March 31, 2016

Project Name: Century Tire Plaza
Address: 195 Kennebec Street, Portland, ME
Project ID: 2015-027
CBL: 34-C-9
Applicant: Northland Enterprises, LLC
Planner: Nell Donaldson

As you are aware, the City of Portland Planning Division has agreed to issue a temporary Certificate of Occupancy for the Chipotle at 195 Kennebec Street prior to the construction of the proposed sidewalk along the Kennebec Street frontage of the site. This temporary Certificate of Occupancy is conditioned upon the construction of this sidewalk, in accordance with the city's Technical Manual, by **May 13, 2016**. In the event that the sidewalk has not been completed by **May 13, 2016**, the City of Portland retains the right to construct the sidewalk and recover the cost through the posted performance guarantee (*See Section 14-530(b)5.c. Non-compliance*).

Note that final sidewalk plans, responding to comments from the city addressed to Fay, Spofford, and Thorndike via email on March 29, 2016 and attached here, should be provided to the city for review prior to sidewalk construction.

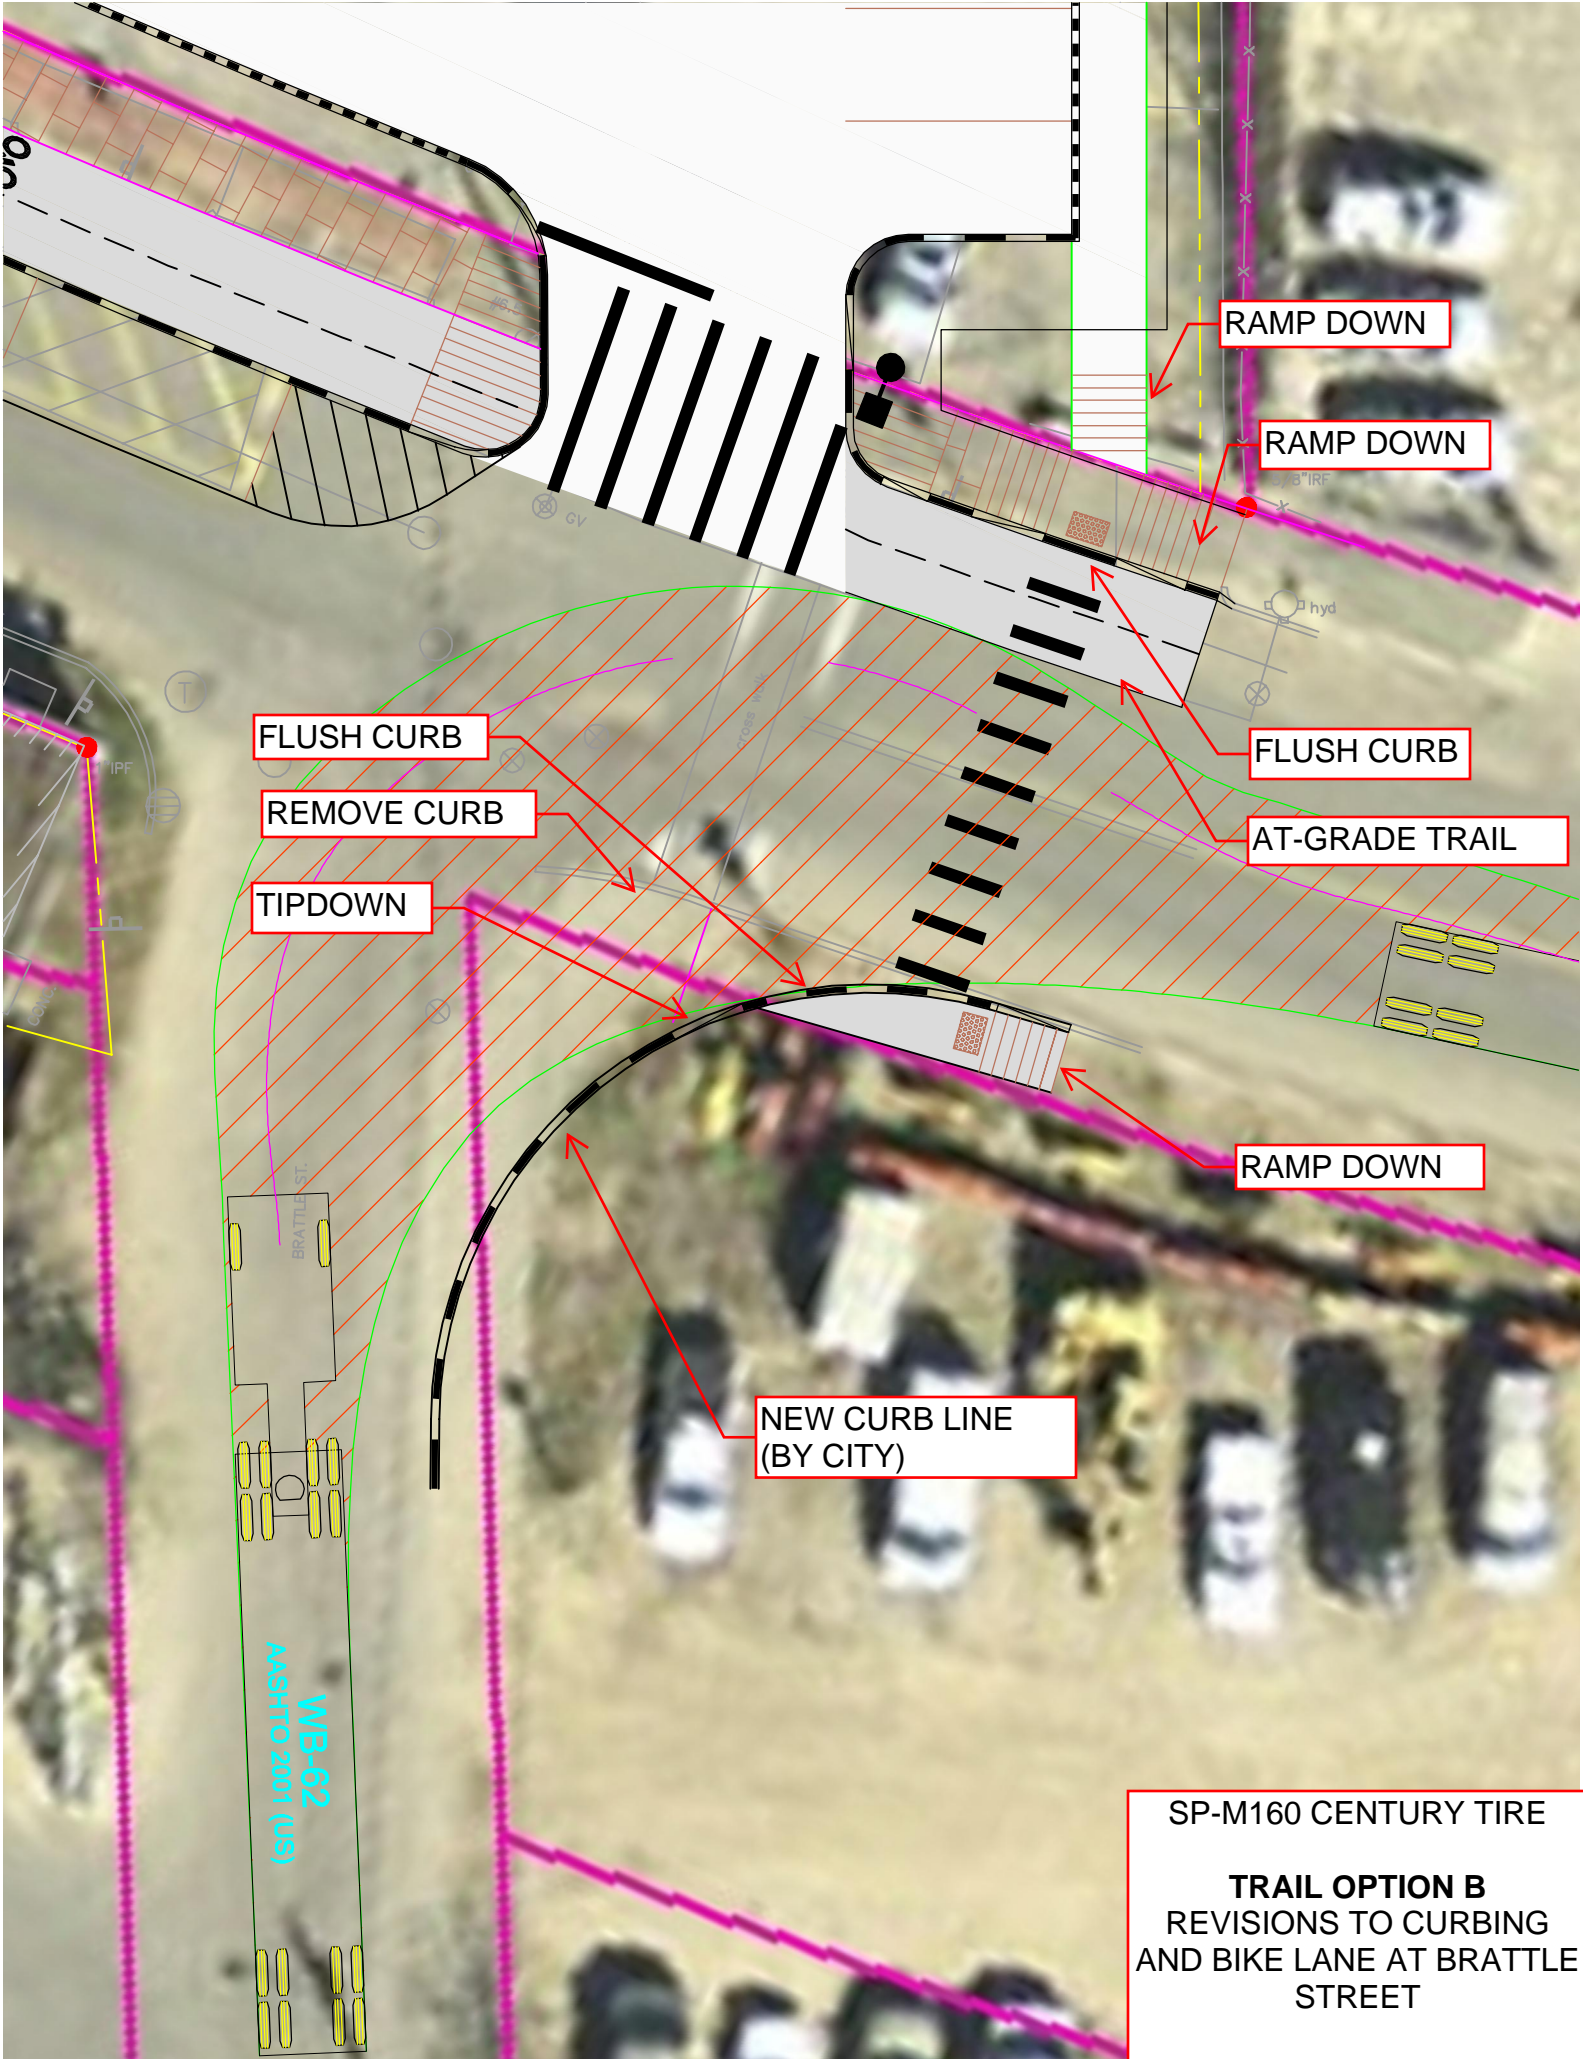
Other than the detectable warning panel needs to be shown (and built) to extend the full width of the ramp on the north side of the crosswalk at Brattle(? - the project side), it seems acceptable. If the curb ramp is 6' wide, the panel needs to be ~6' wide, etc, per ADA.

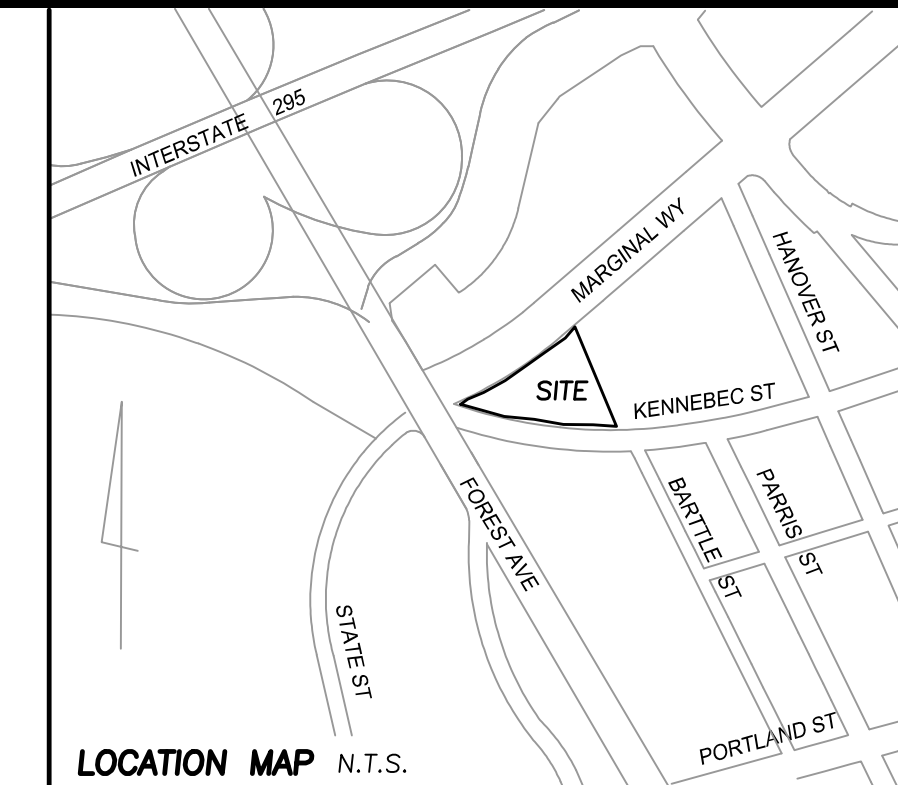
The only other comment is that I believe the crosswalk marking on Kennebec doesn't meet the Technical Manual spec. (See Figure I-22, or even the approved site plan, for the preferred design).
